From: [Thomas, Patrick](#)
To: [West Midlands Interchange](#)
Subject: WEST MIDLANDS INTERCHANGE - HIGHWAYS ENGLAND'S DEADLINE 3 SUBMISSION Your Ref:TR050005
Our Ref: 20015068
Date: 24 April 2019 13:00:13
Attachments: [Highways England's further comments following Applicant's response to ExA's Written Questions - 240419.docx](#)

Examining Authority's Question		Highways England Comment	Applicant's Response	Highways England Comment to Applicant's Response	
1.0	General and Cross-topic Questions

Fig 4.4: Indicative Phasing Plan

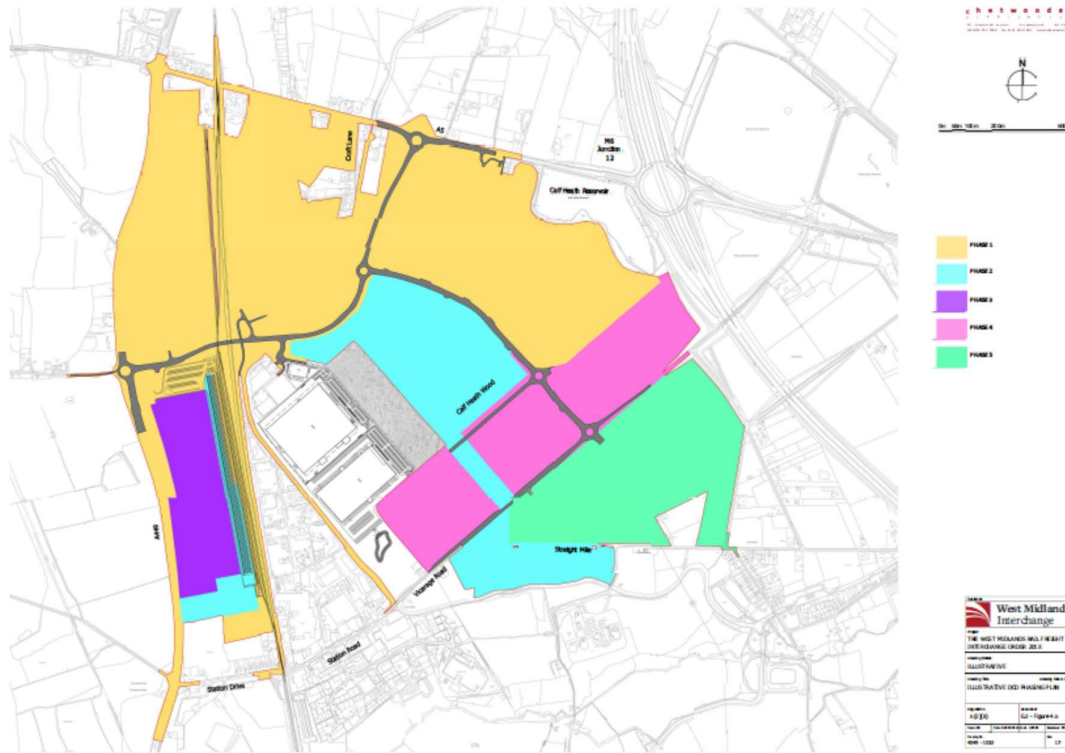
1.7.10	The Applicant	<p>Development Phasing</p> <p>Paragraph 4.3.1 states that, based on the indicative phasing plans, all highway infrastructure will have been introduced by</p>	<p>We have noted the applicant's phasing proposal and its treatment in the traffic analysis.</p>	<p>ES Figure 4.5 is an indicative drawing of the site layout based around phasing of warehouse units. It is acknowledged that paragraph 4.3.1 of the Transport Assessment (Document 6.2, APP-114)</p>	-

Examining Authority's Question		Highways England Comment	Applicant's Response	Highways England Comment to Applicant's Response	
		<p>the end of indicative Phase 1. However, it is not clear that this would be the case from examination of ES Figure 4.5 which appears to show some of this infrastructure in later phases.</p> <p>Can the Applicant produce a plan that clearly indicates the anticipated phasing of the highway infrastructure and site estate roads?</p>	<p>We have confirmed the applicant has tested to our satisfaction the provision of 147,000m² of development prior to completion of the A449/A5 link road and opening of the rail terminal. The traffic assessments are based on the full level of infrastructure being available immediately after that point.</p>	<p>is incorrect as not all highway infrastructure will be introduced by the end of indicative Phase 1.</p> <p>A plan has been produced provided at Appendix 14 of this document which shows the phasing of proposed highway mitigation and access infrastructure as per the Requirement 25 set out in the dDCO. All highway mitigation would be delivered by the end of Phase 1; however, some elements of the vehicular access strategy may come forward later than Phase 1 for example the accesses for the land served via Vicarage Road.</p>
